REVIEW of LVIA

CHERWELL DISTRICT COUNCIL

Application reference: 22/01682/F - Land North of Manor Farm, Noke

April 2024

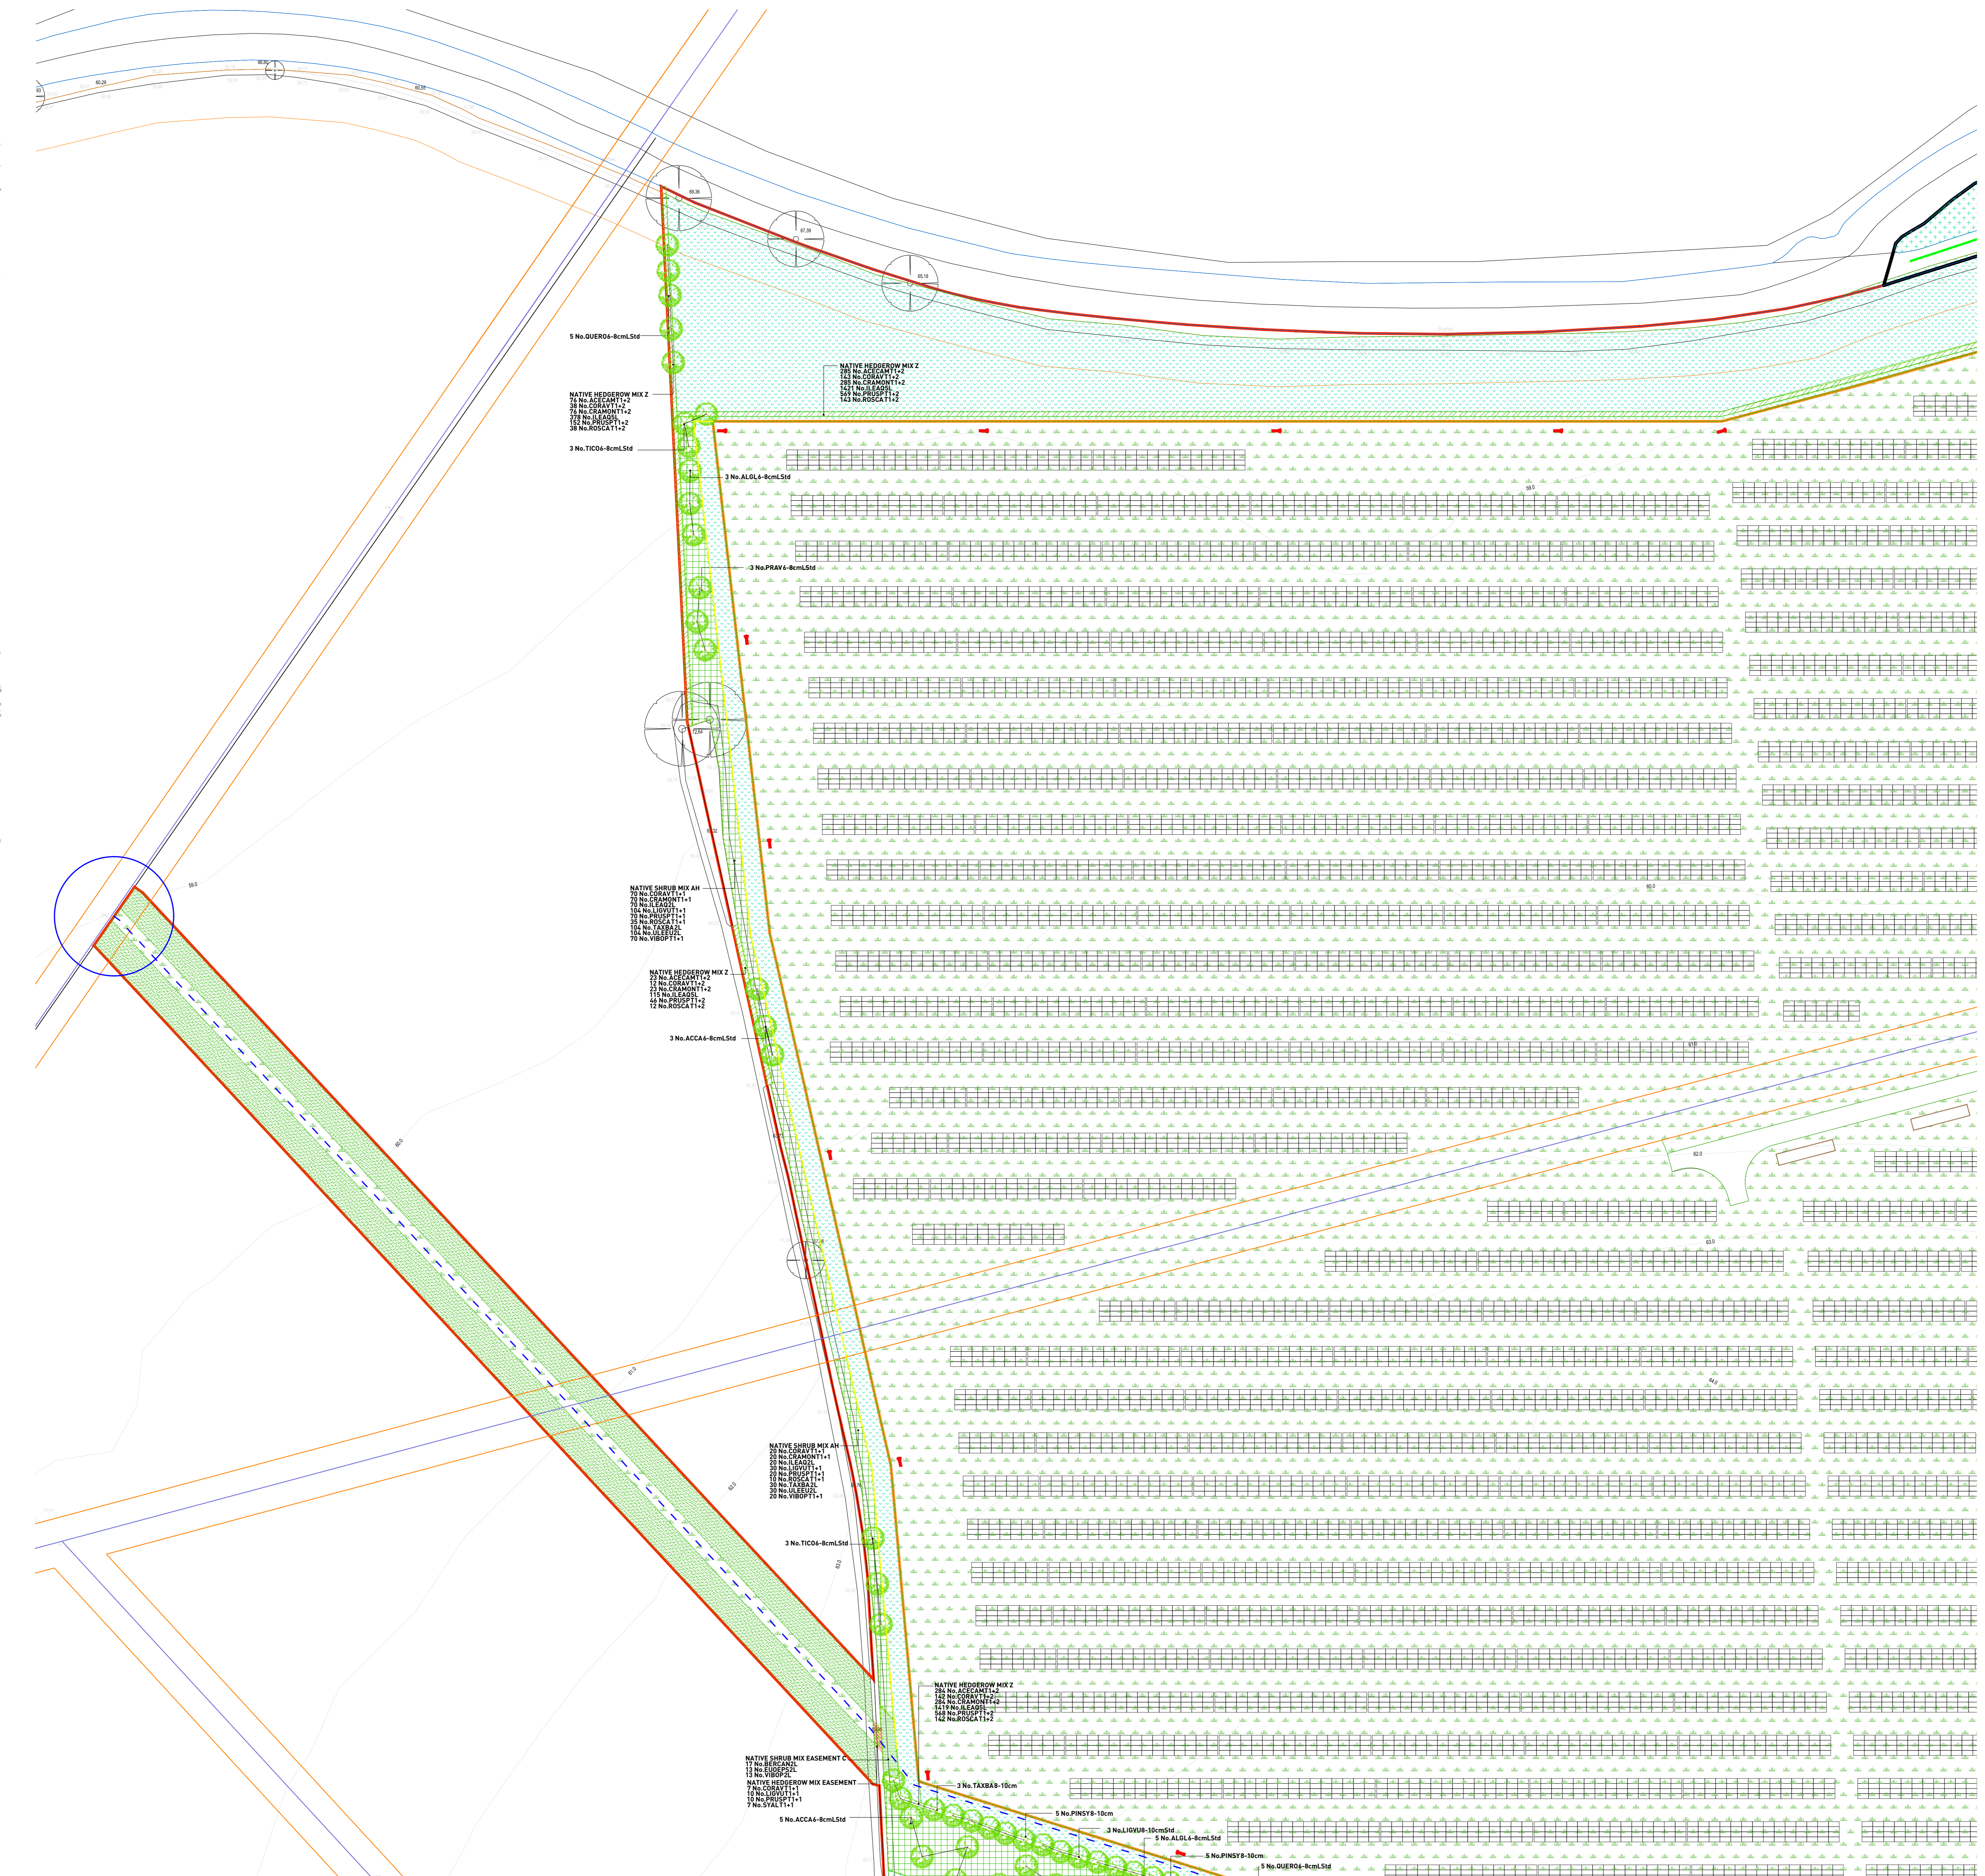
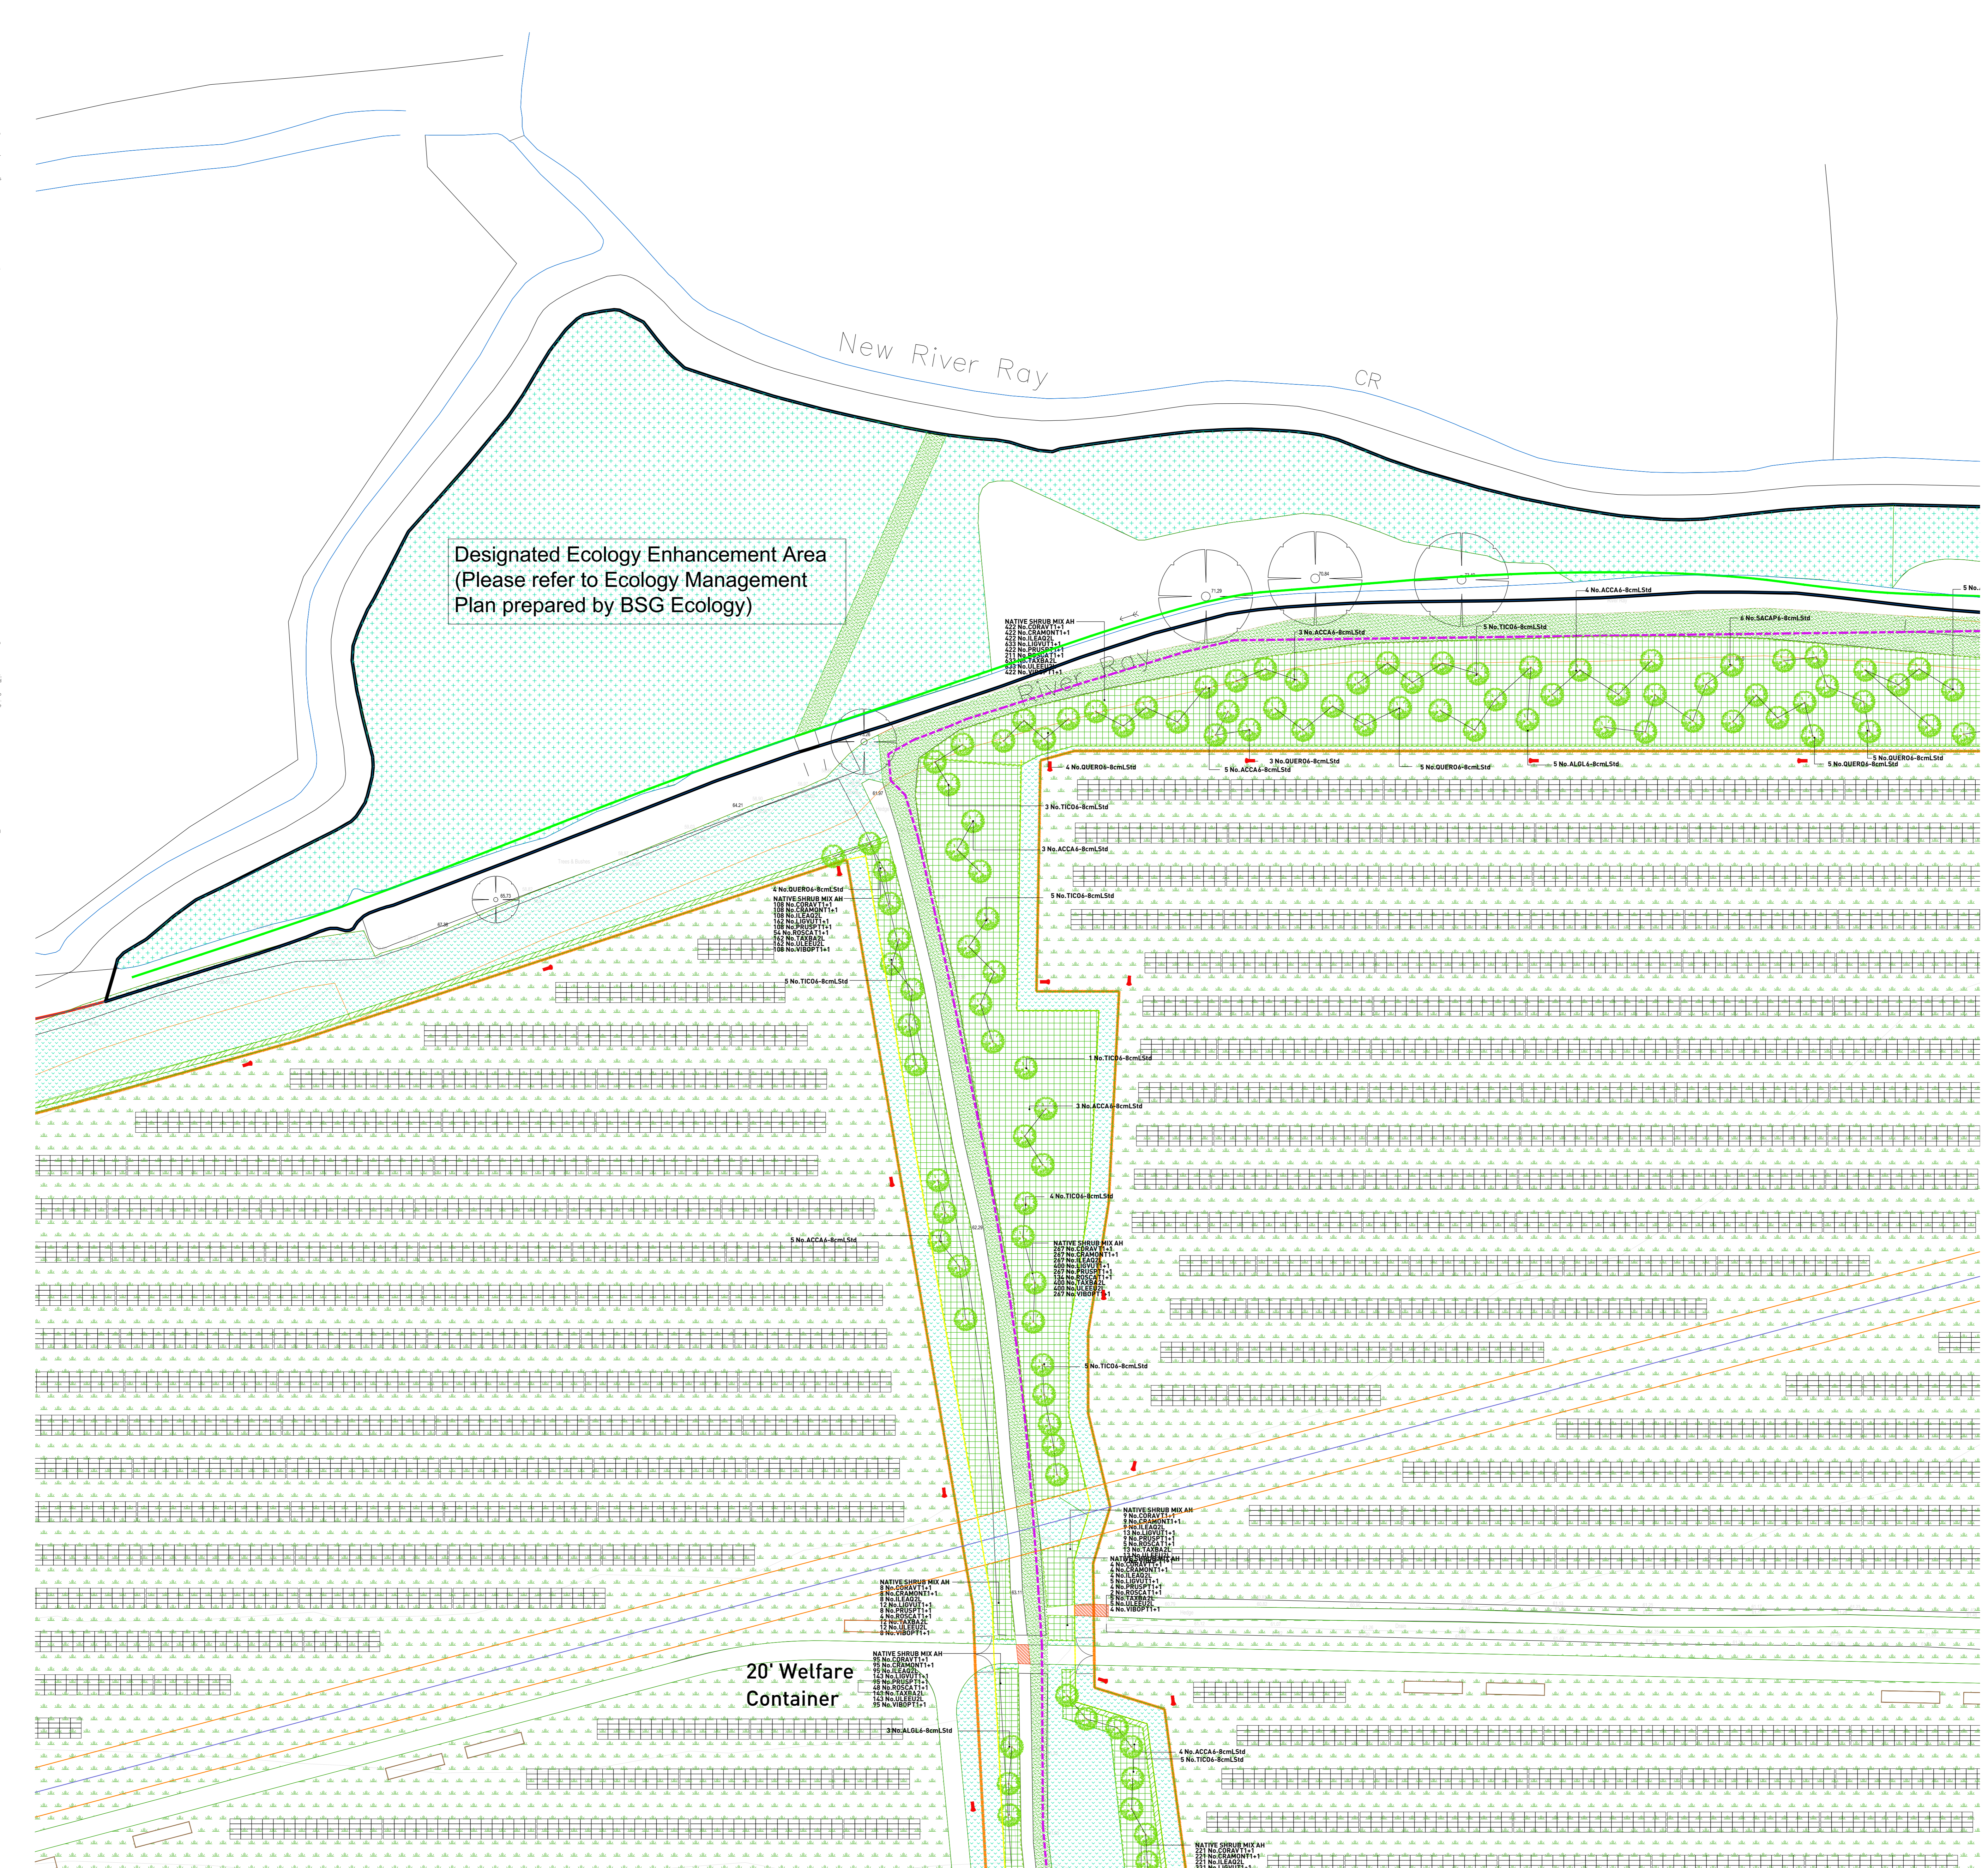
- 3.30 Security fencing is described as having an “offset for maintenance purposes of 4m generally and 1m along the northern boundary adjacent to the river corridor beyond which there is significant proposed planting” (LVIA para. 5.21). The offset is assumed to be from the site boundary but this is not clear. The proposed 2m clearance between the security fencing and existing hedgerow is subsequently described as “enhancement” at LVIA paragraph 5.31 which should be corrected as the security fencing and need to create screening of it, does not enhance.

- 3.32 The proposals incorporate a relatively high percentage of evergreen species

compared to local patterns and species compositions that are typical of the landscape character of the area. Whilst this would assist in providing year round screening value, it is not in our opinion in-character with the wider and local landscape context.
